Subject: Land adjacent to Church Farm Barn Horsemere Green Lane Clymping BN17 5QZ - CM/64/21/PL

Planning Application Reference: CM/64/21/PL

Proposal: Use of land for Class B8 (Storage) for caravan storage. This application may affect the setting of listed buildings & is in CIL Zone 3 (Zero Rated) as other development

Drawing Title
Site Layout - AS PROPOSED

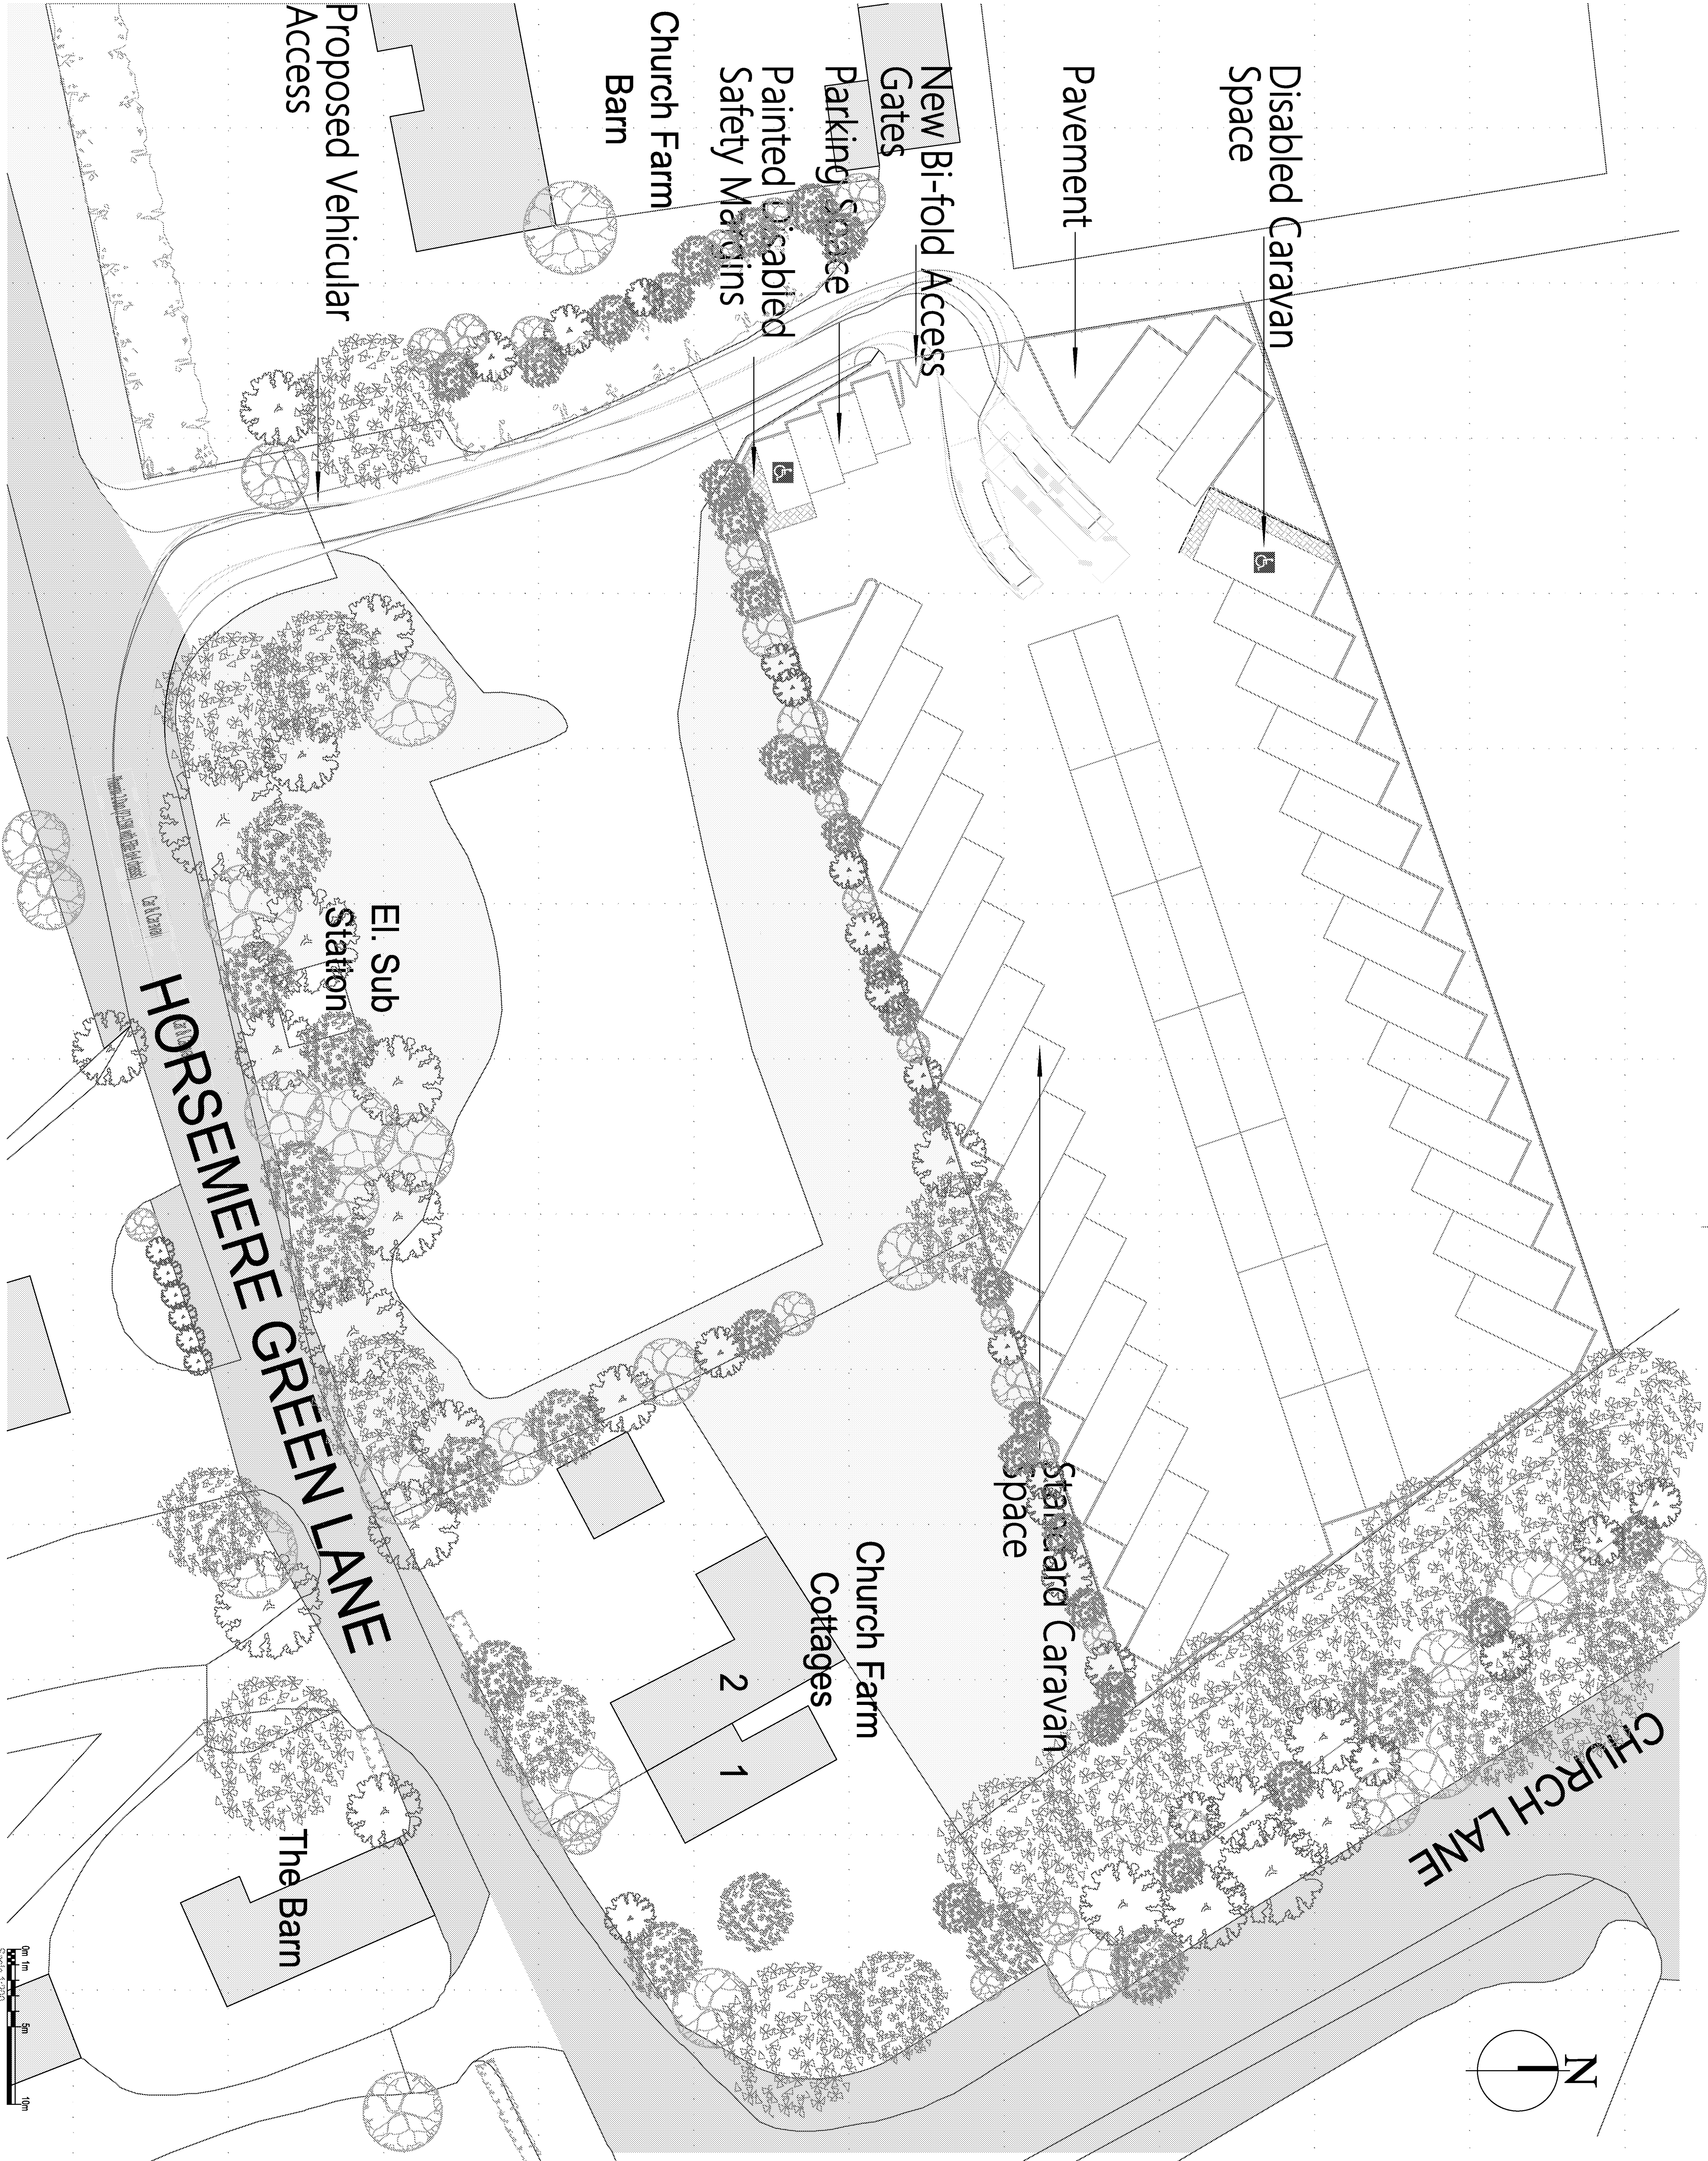
Before first use of the proposed development the access roads and parking areas shown on the Location plan shall be completed with a hard surface finish and thereafter permanently retained for parking and manoeuvring purposes.
